ENG-SP20003-R5-PrelimPlan.pdf Markup Summary

COVER SHEET

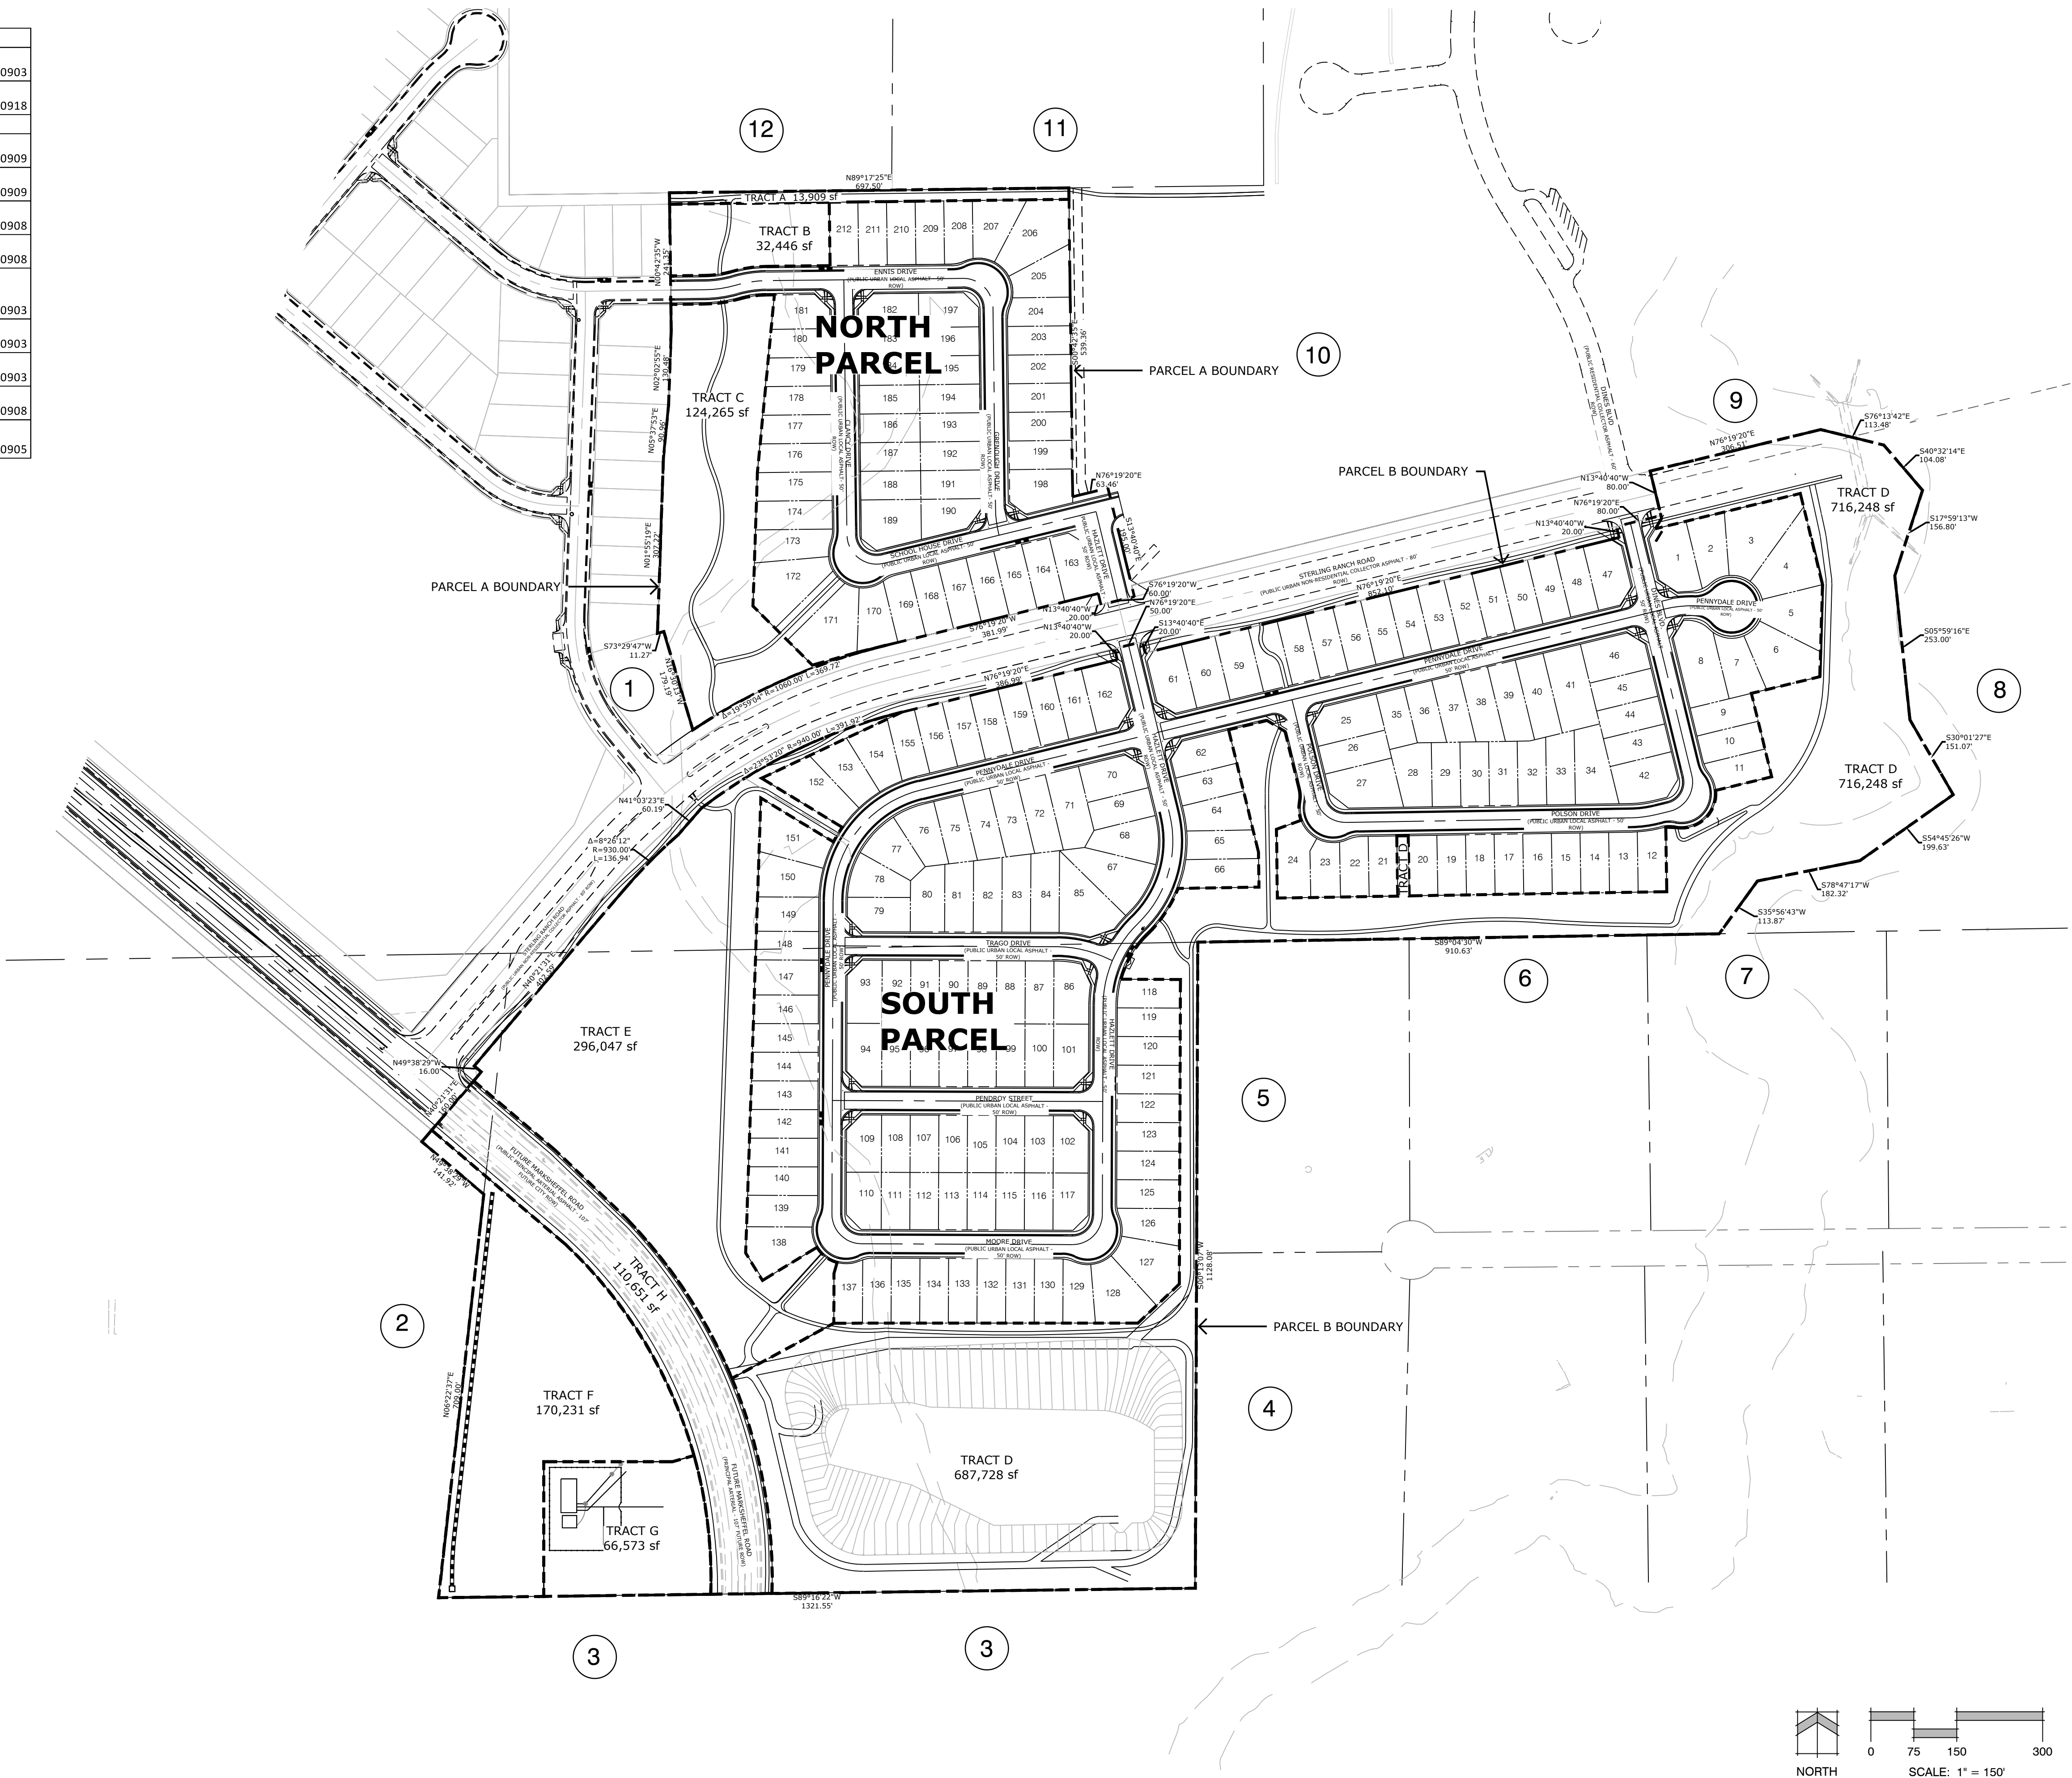
Shoep slopes along Sand Creek Drainage
consideration: 10% drainage swales along western portion of
at 7:0 Feet. Lots 109,111,115,145,147,173,174,180,181,
to high groundwater in the area. All foundations shall occur
as required by the District. No basements will be allowed.
0.18,192,193,195-197,207,208. Use for areas of Seasonal 5

EPC Modified Type C or Type A Curb & Gutter

PRELIMINARY
PLAN

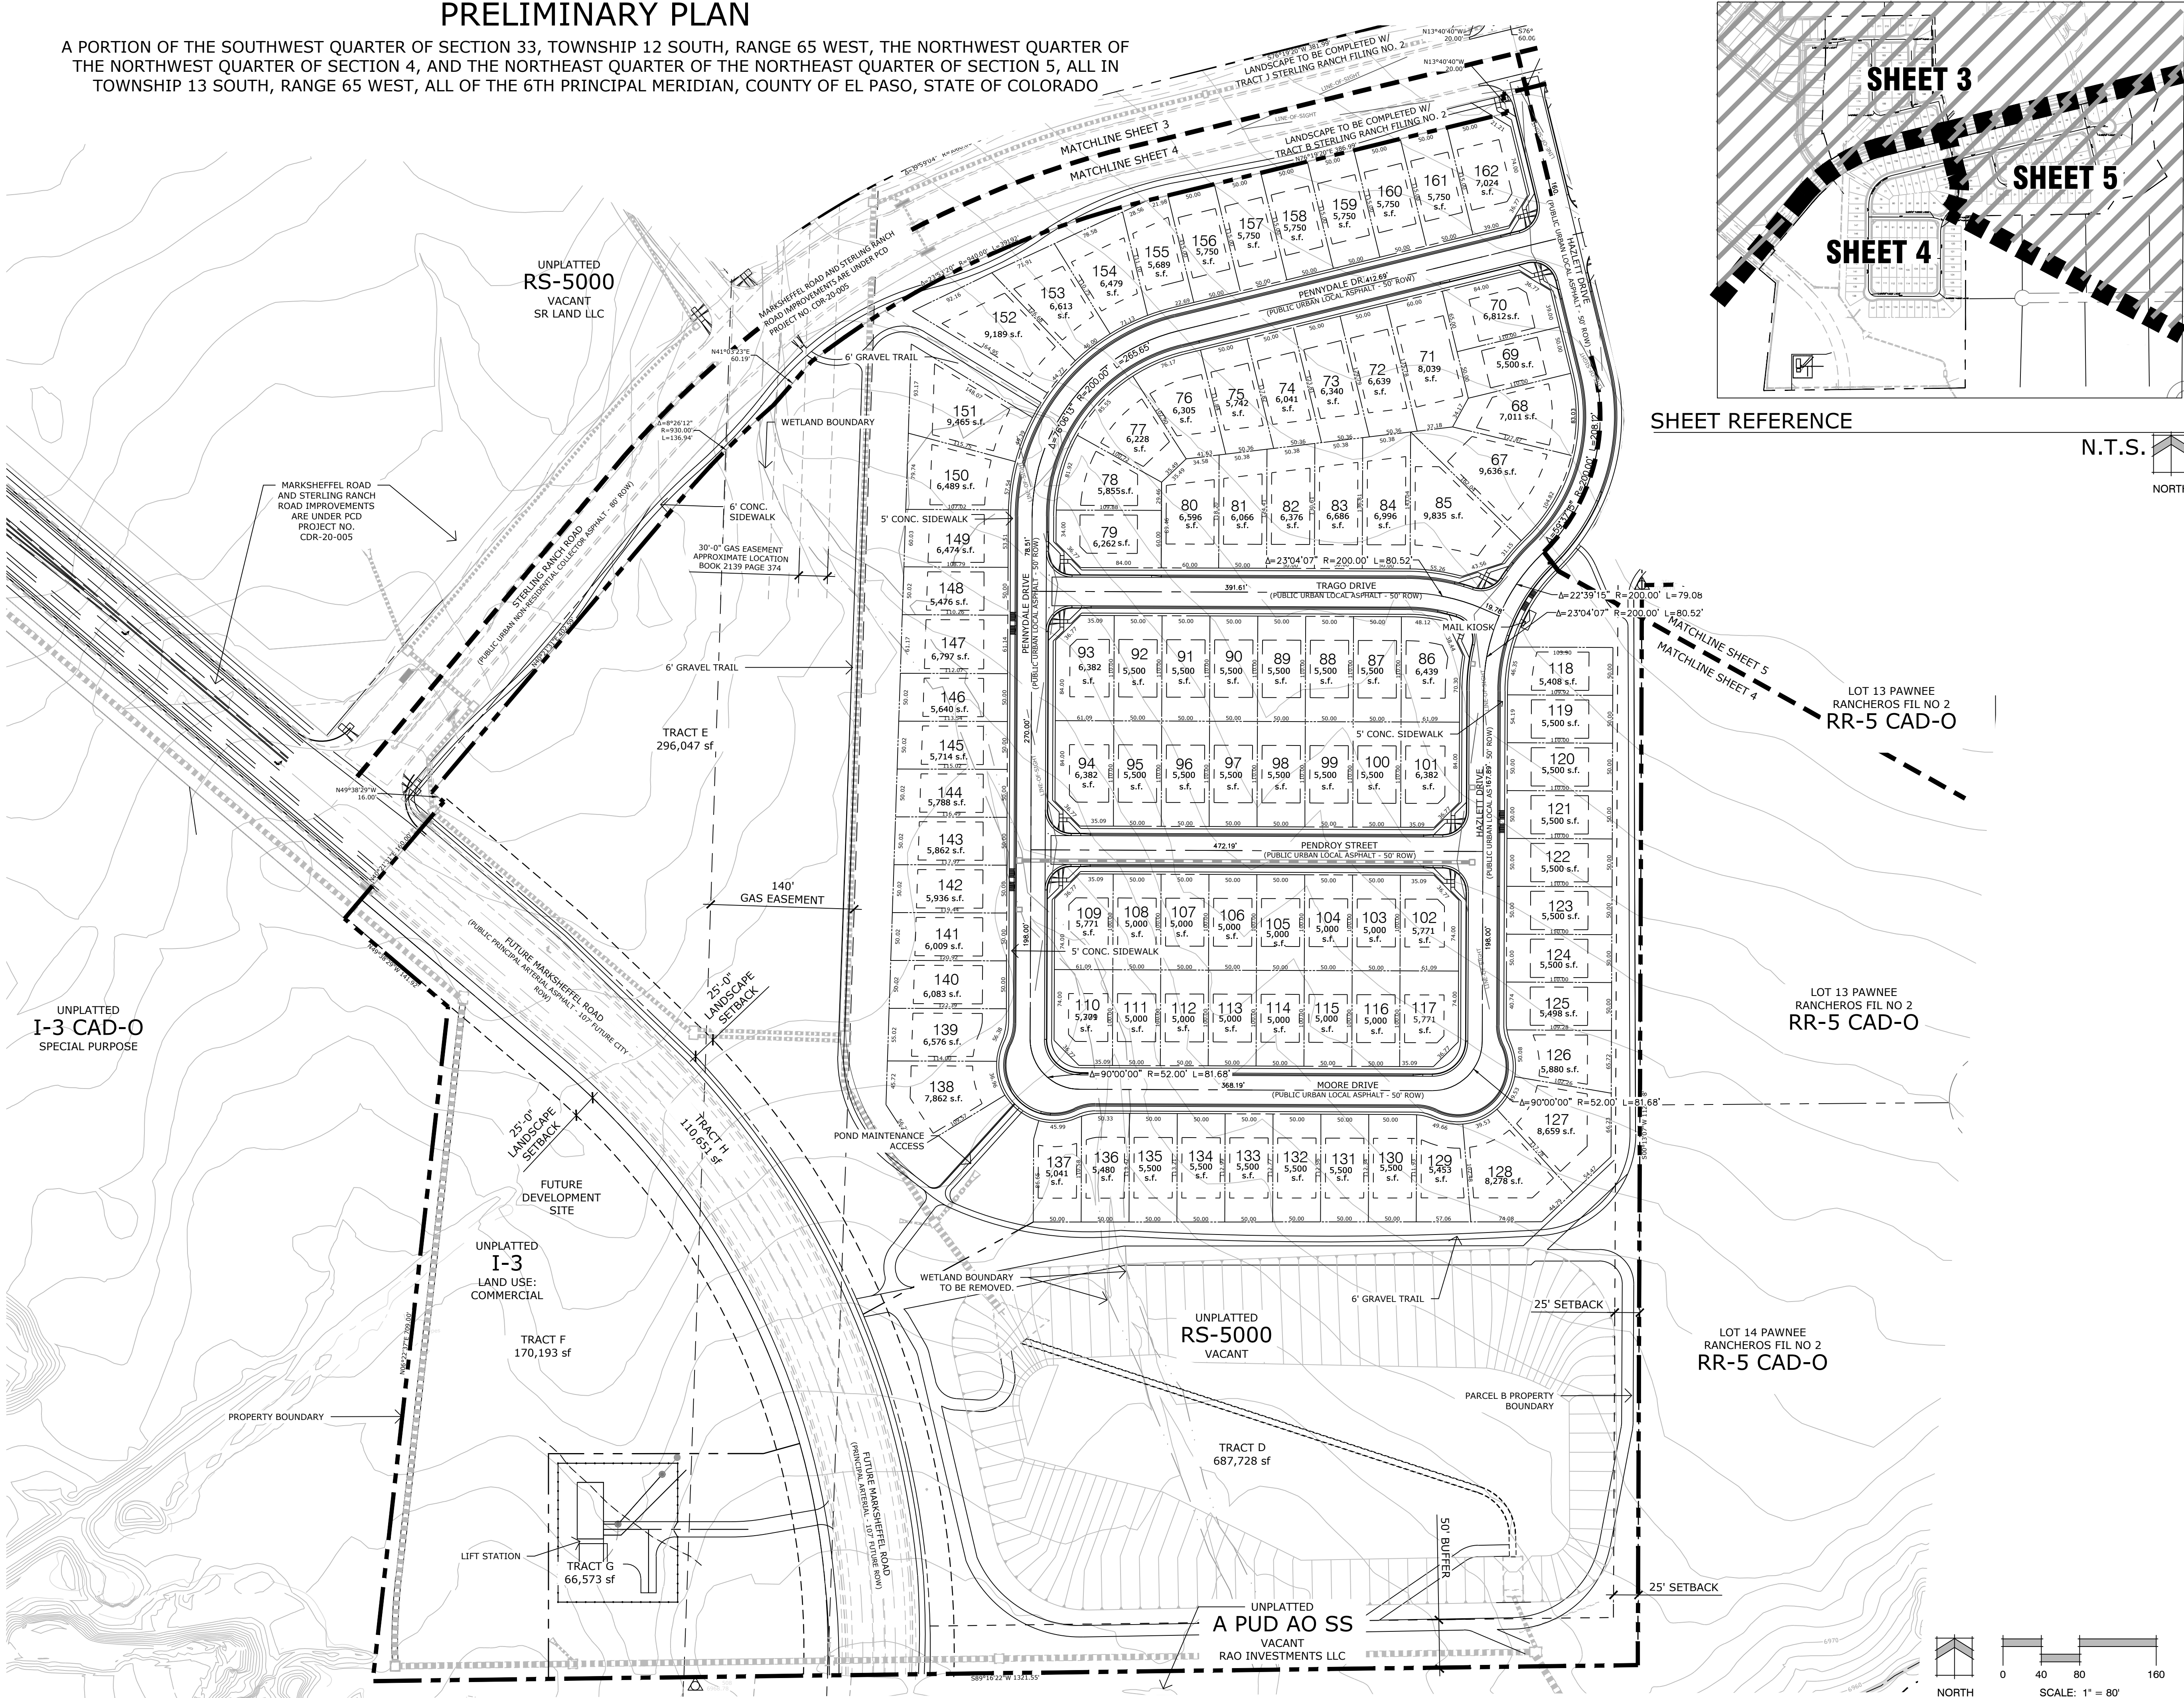
dimension of tract

dimension of tract; check all sheets and add

PRELIMINARY
PLAN

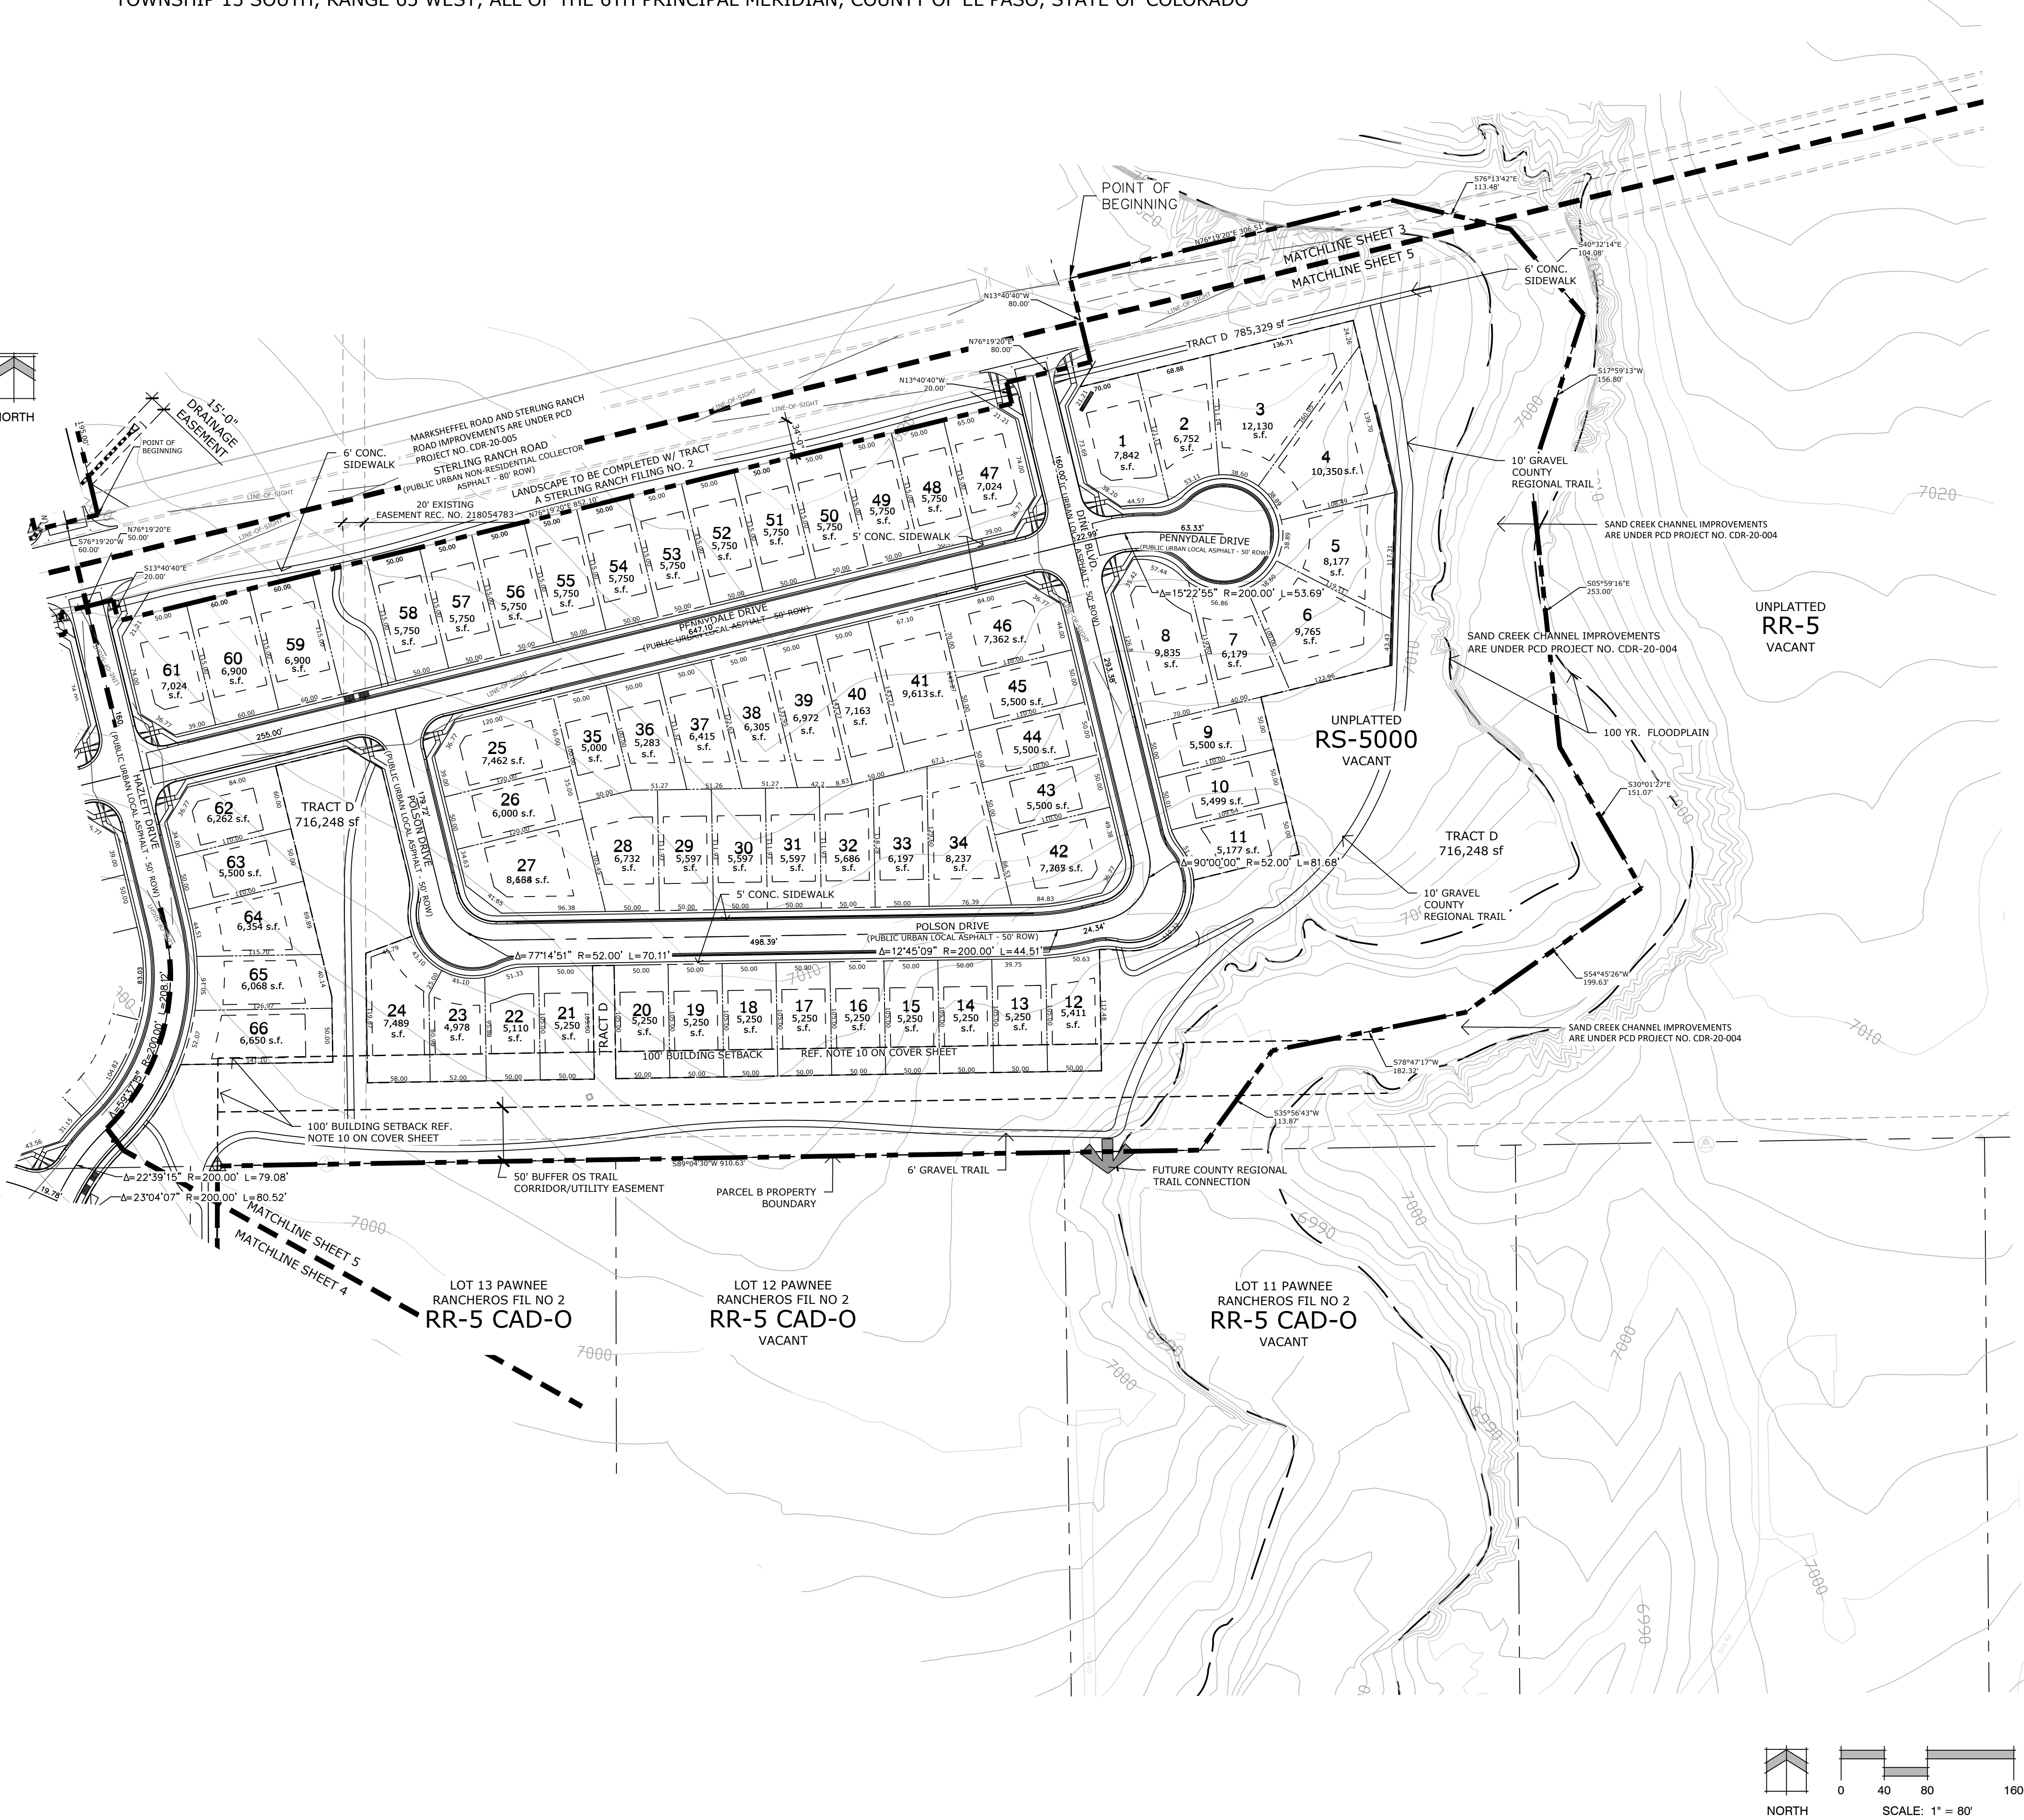
dimensions on all tracts just like you do for lots..REpeat comment
